RE: SSD 9143 Goulburn Poultry Processing Mixed Use Development

Thank you for the opportunity to comment on the Environmental Impact Statement (EIS) and accompanying documentation for the establishment of the Goulburn Poultry Processing Mixed Use Development, located at 52 Sinclair Street in the Goulburn Mulwaree Council Local Government Area. Murrumbidgee Local Health District makes the following submission for your consideration.

Tabitha Holliday
Environmental Health Officer

EROSION & SEDIMENT CONTROL PLAN  
 PROPOSED PROCESSING FACILITY  
 52 SINCLAIR STREET,  
 GOULBURN  
 WOODLAND RIDGE POULTRY PTY LTD

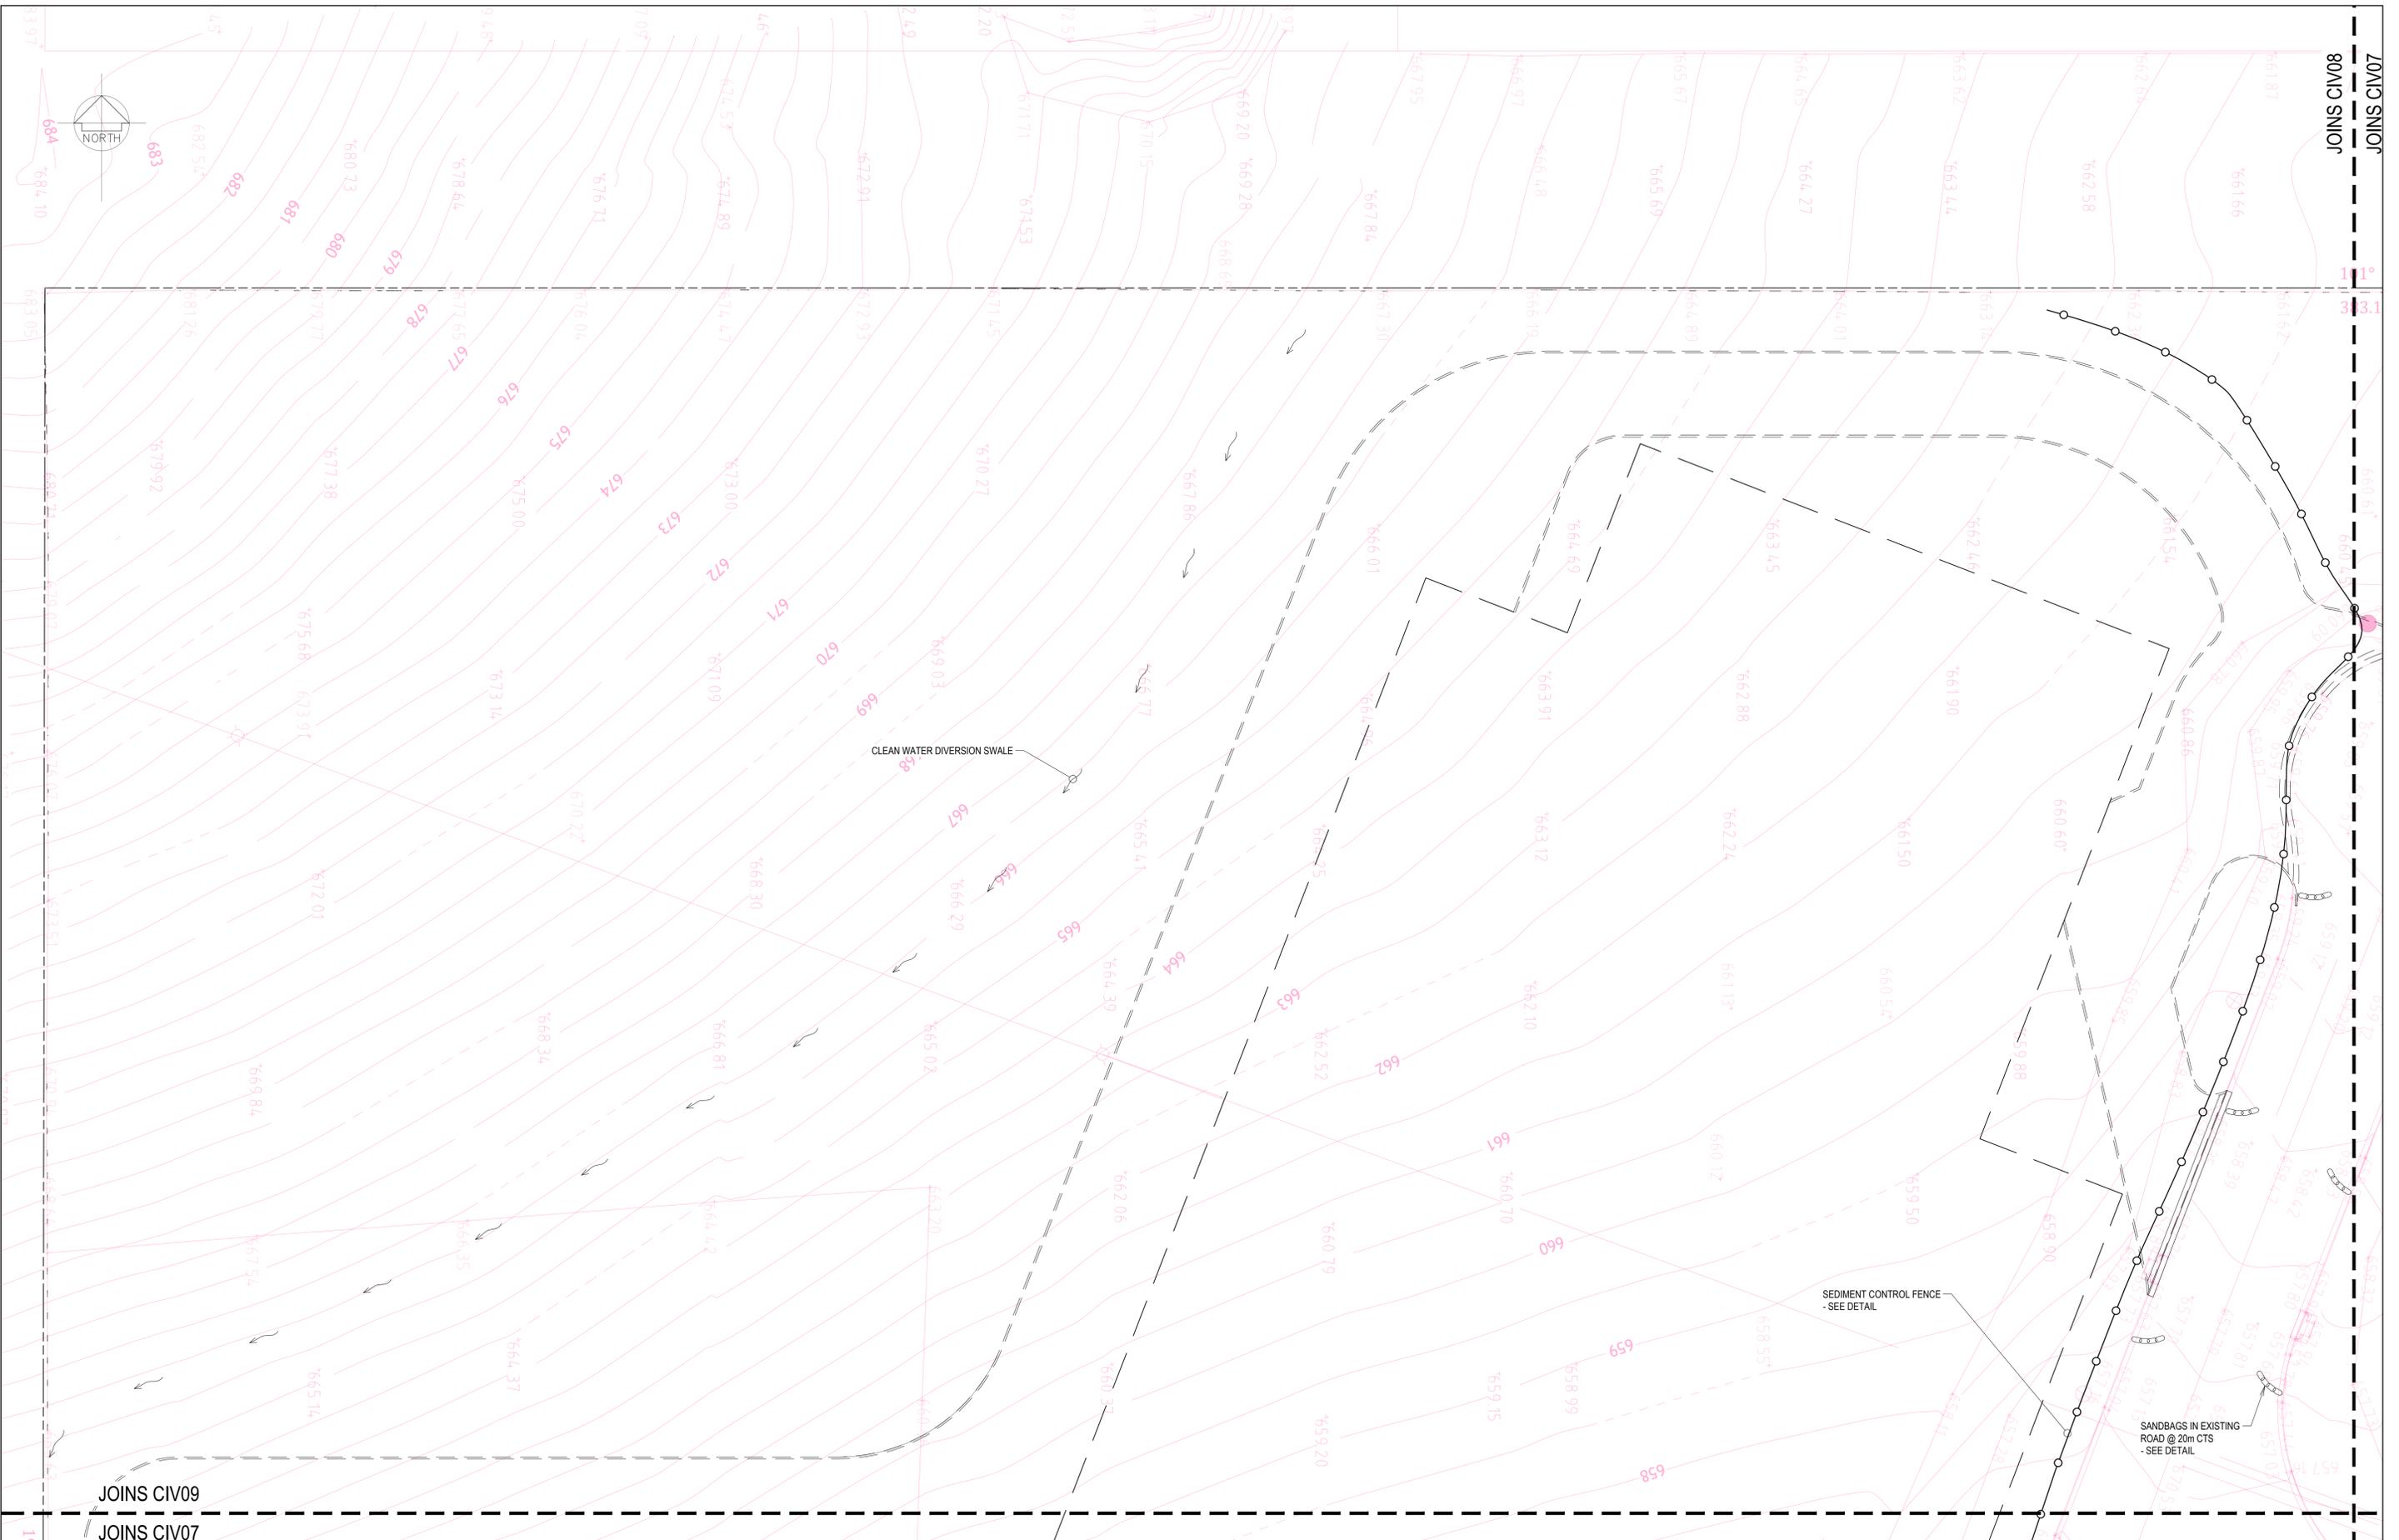
1. The Stormwater Management Report outlines the following rainwater storage tanks to be installed:
 - a. 50KL to collect roof water from the cold store and corporate office
 - b. 35KL to collect roof water from the child care centre; and
 - c. 800KL to collect roof water from the process facility, live bird facility and products processing building.

While the beneficial re-use of rainwater is supported by NSW Health, where a reticulated public water supply is available, it is recommended that the public water supply is used for purposes including drinking and cooking because it is filtered, disinfected and generally fluoridated. Further information can be found in the "Rainwater Tanks Where a Public Water Supply is Available" located at: https://www1.health.nsw.gov.au/pds/ActivePDSDocuments/GL2007_009.pdf

In this regard, can the developer please confirm that the roof water will not be used for on-site drinking and cooking purposes (particularly the child care centre and staff amenities).
